**Consultation Response from KC,
Lead Local Flood Authority**
2026/91304 Rose And Crown Inn, 132, Knowl Road, Golcar, Huddersfield, HD7 4AN
Variation condition 2 (plans) 9 (drainage), 10 (drainage), 14 (highways) and 17 (provision of footway) on previous permission 2024/90839 for erection of 7 dwellings and associated infrastructure following partial demolition of existing public house (within a Conservation Area)
Date Responded: 22/06/2026
Responding Officer: Martin Stephenson
Responding Ref: 1
Previous response by the LLFA

Variation of Drainage Conditions

- No. 9 (Foul & Surface Water drainage),
- No. 10 (Exceedance Flood Routeing)

## Appendix C – Drainage Details SH1

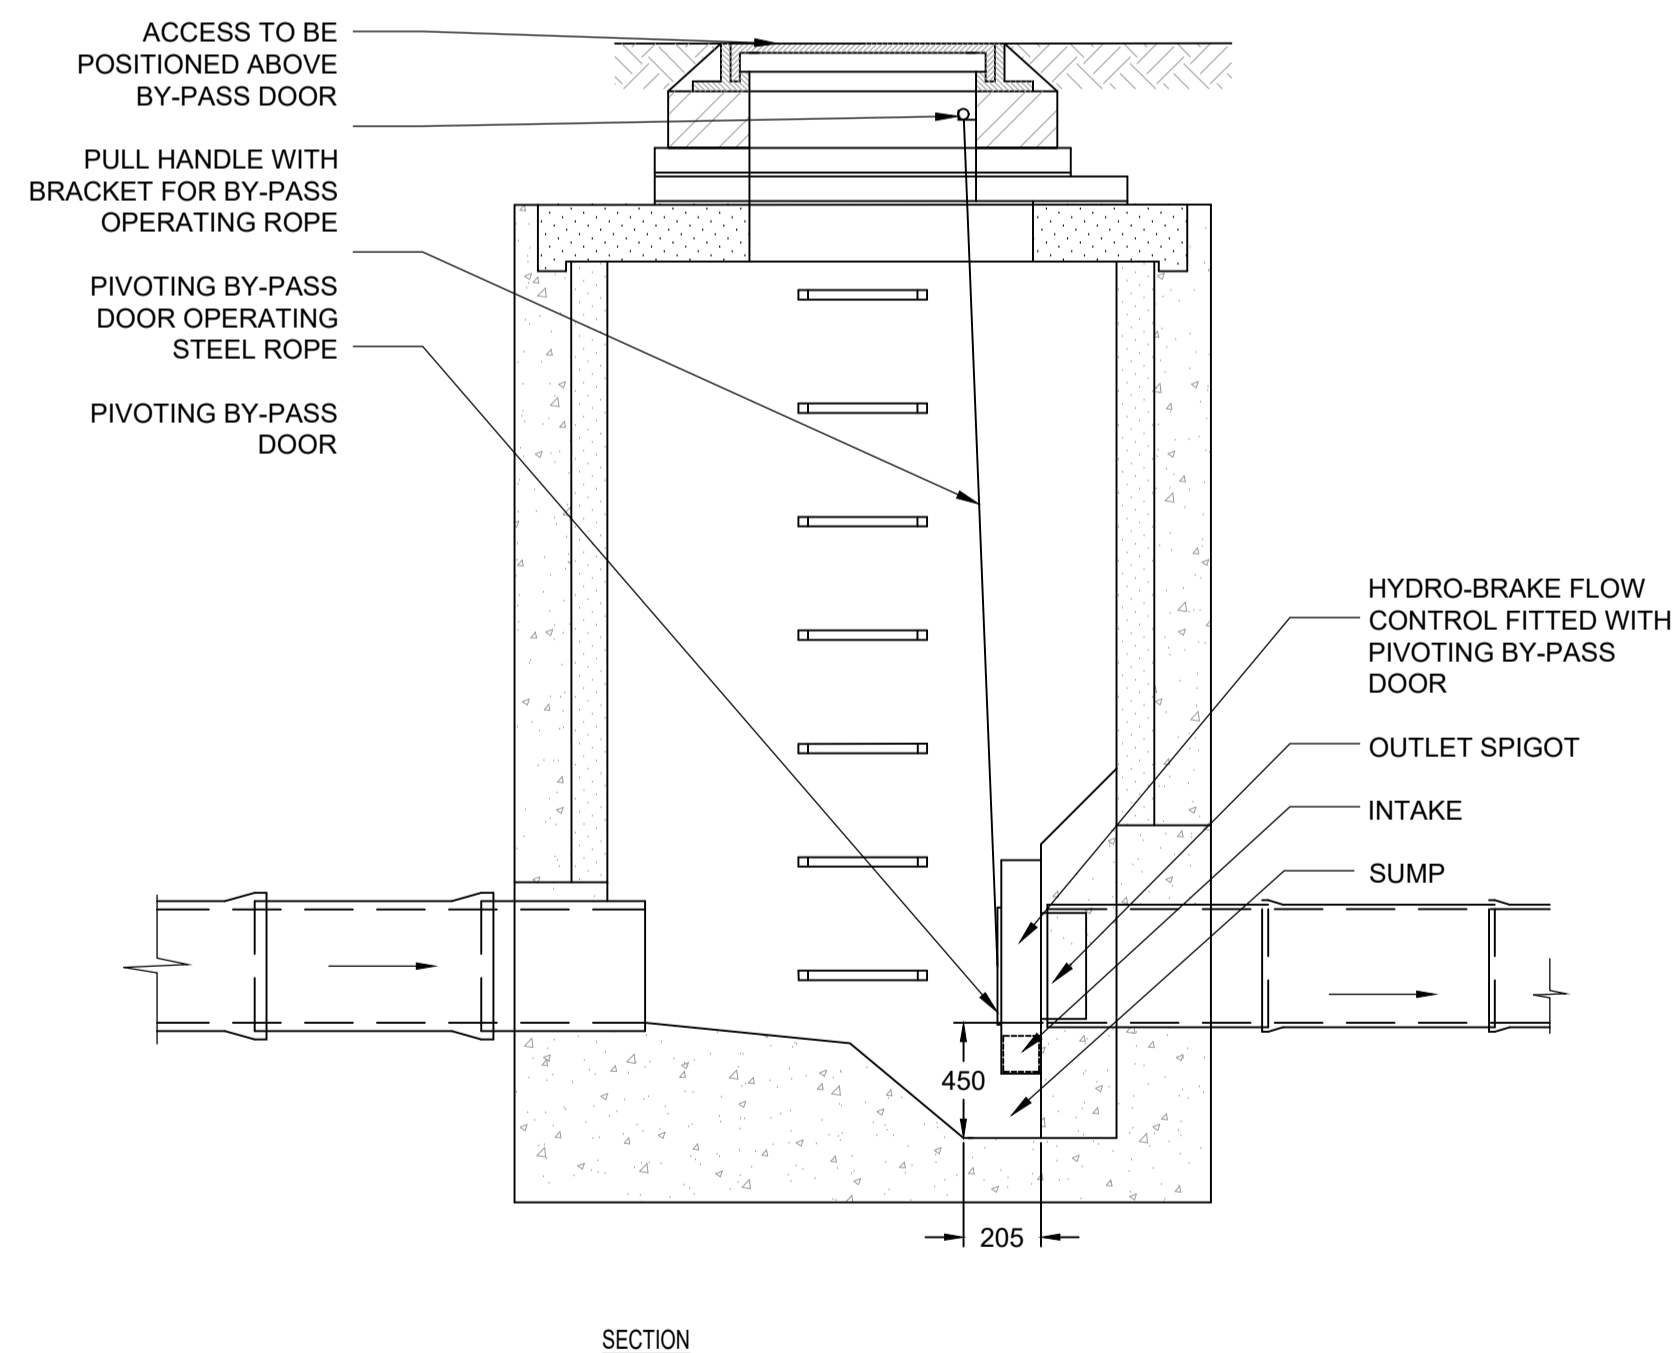
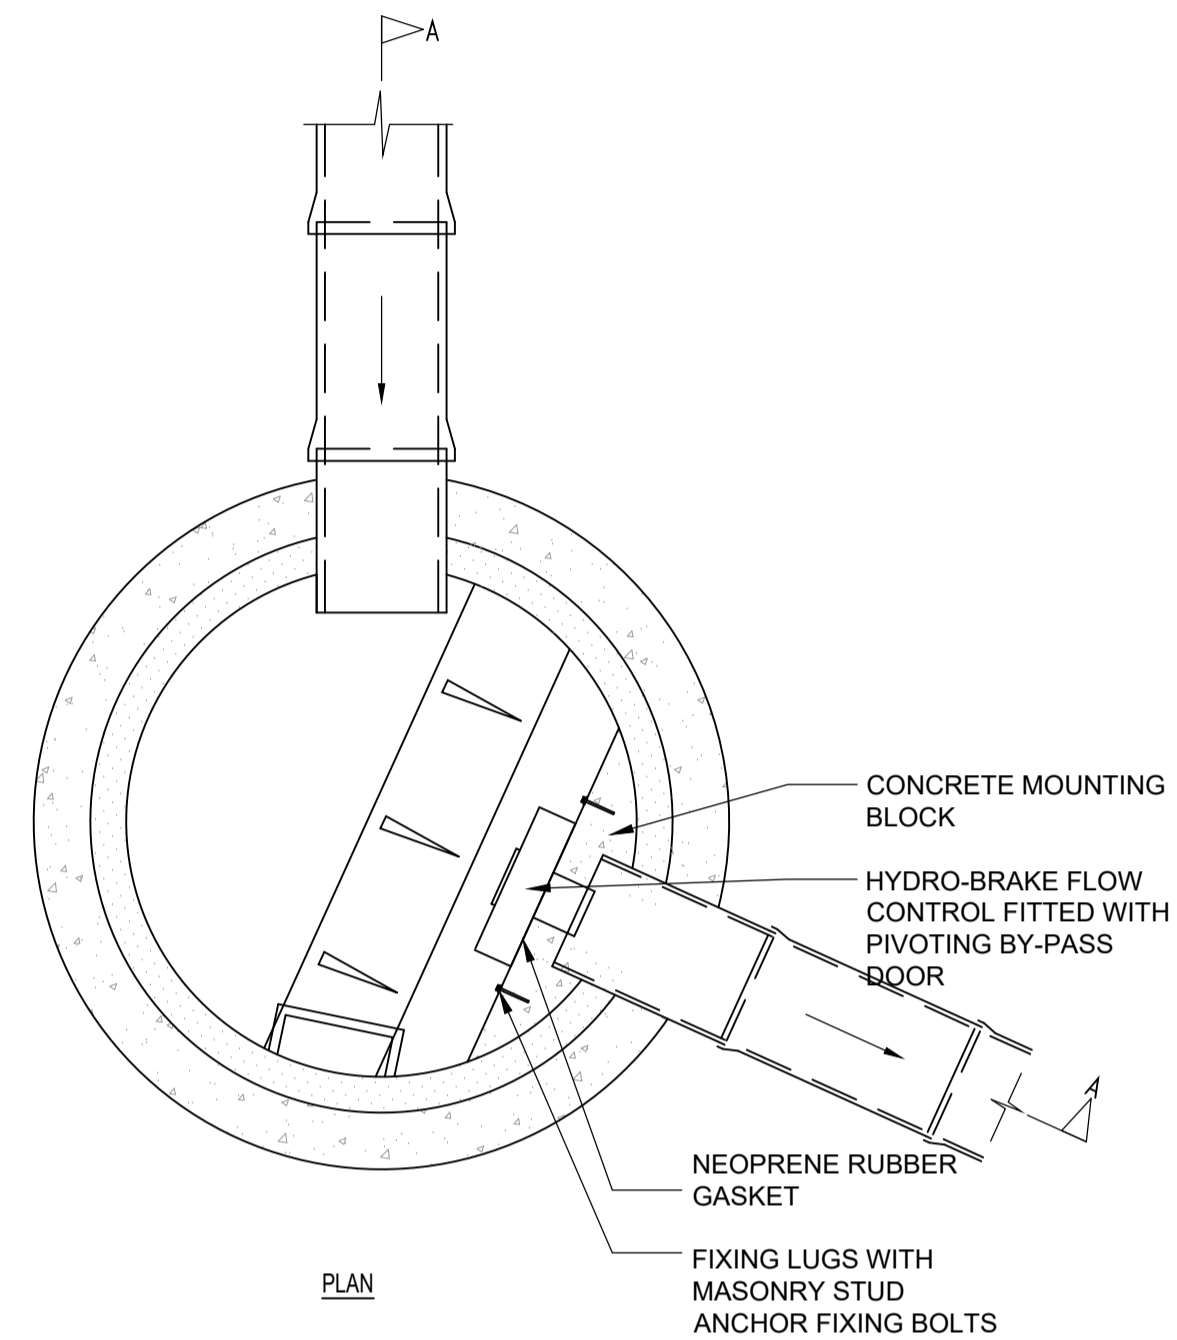
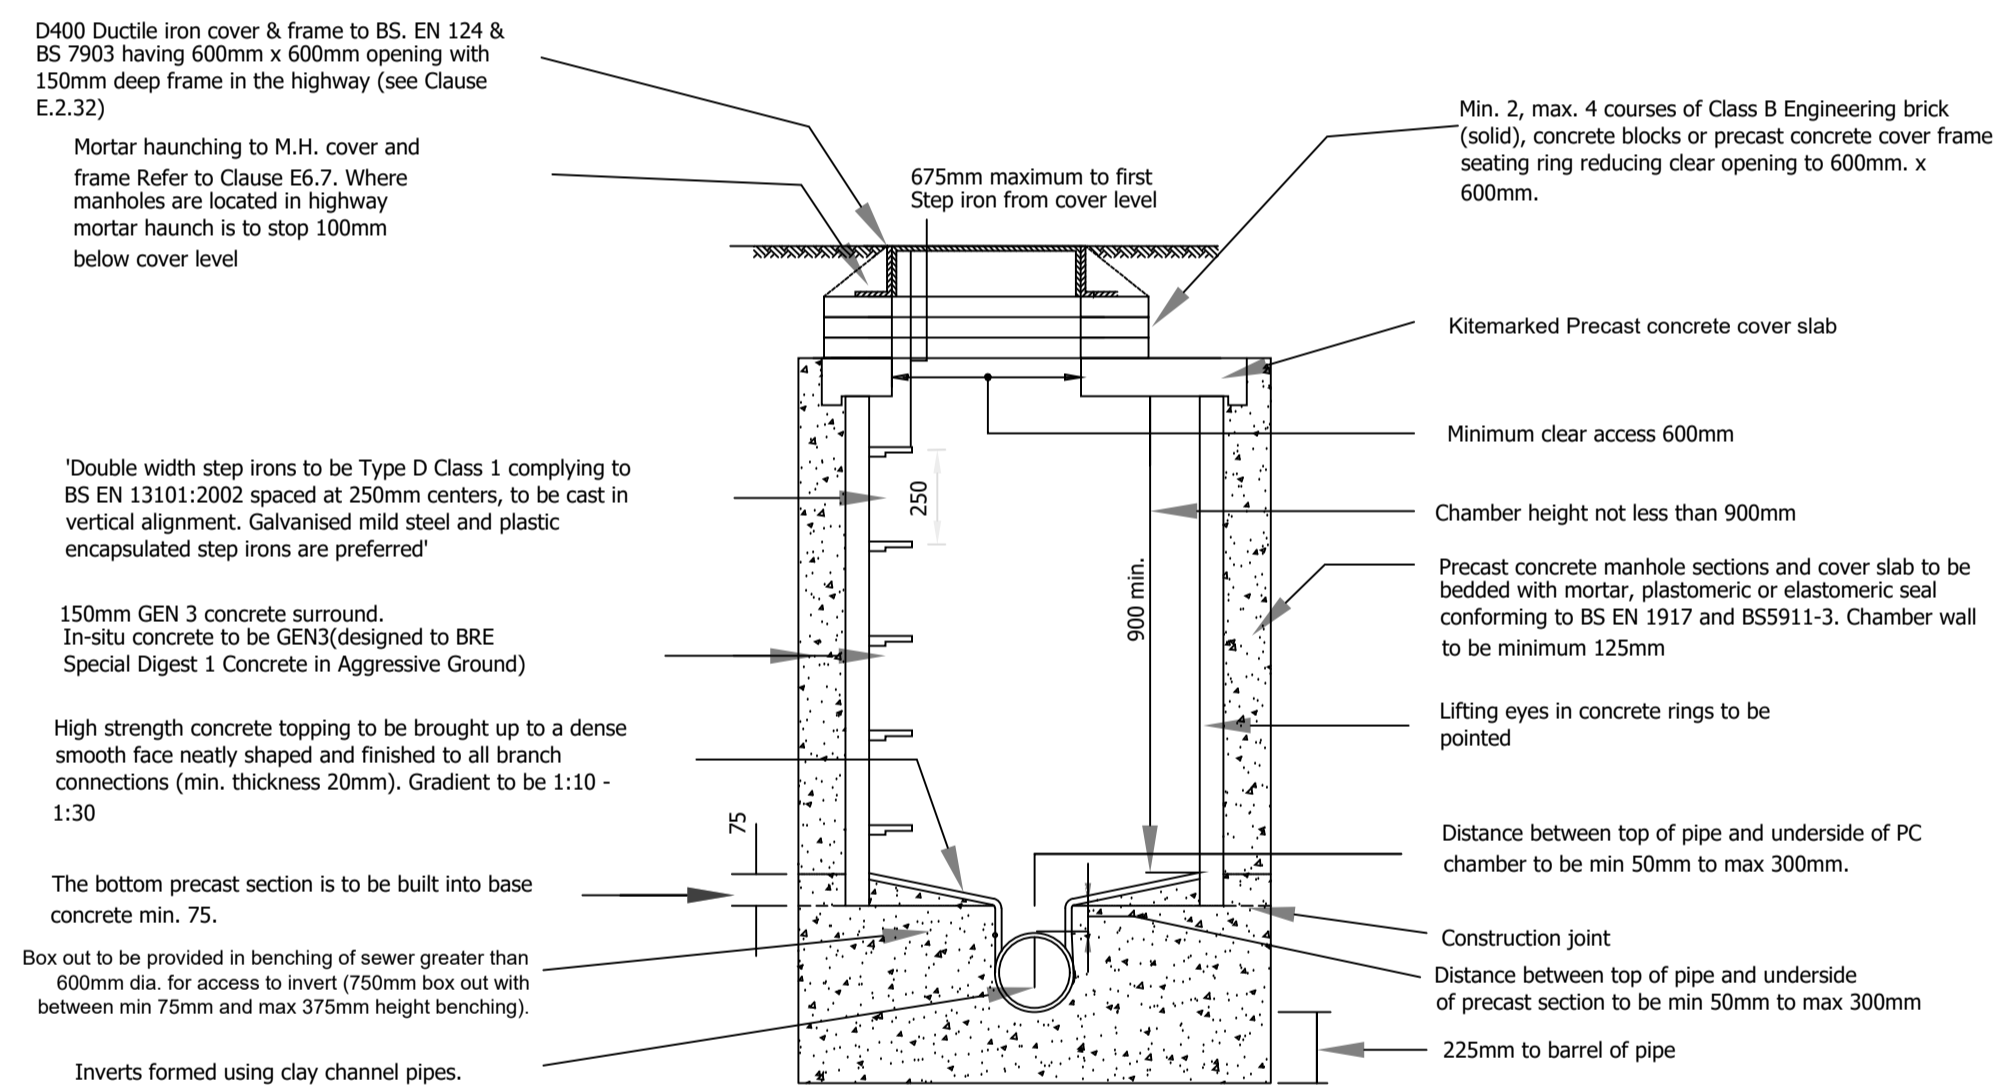
However, no construction details are provided of the proposed attenuation storage within the sub-base of the permeable paved parking areas. The details should state the depth of storage, top level and bottom level and plan area at each of the parking locations together with details of the perforated pipework, any proposed geomembranes, and construction details of the permeable paving. Details of 1200mm dia PCC MHs deeper than 1.5m (as indicated in the Manhole Schedule in the Causeway calculations) should also be given in Appendix C of the Drainage Design Report

Therefore, **further information** is required before this variation to the condition can be given.
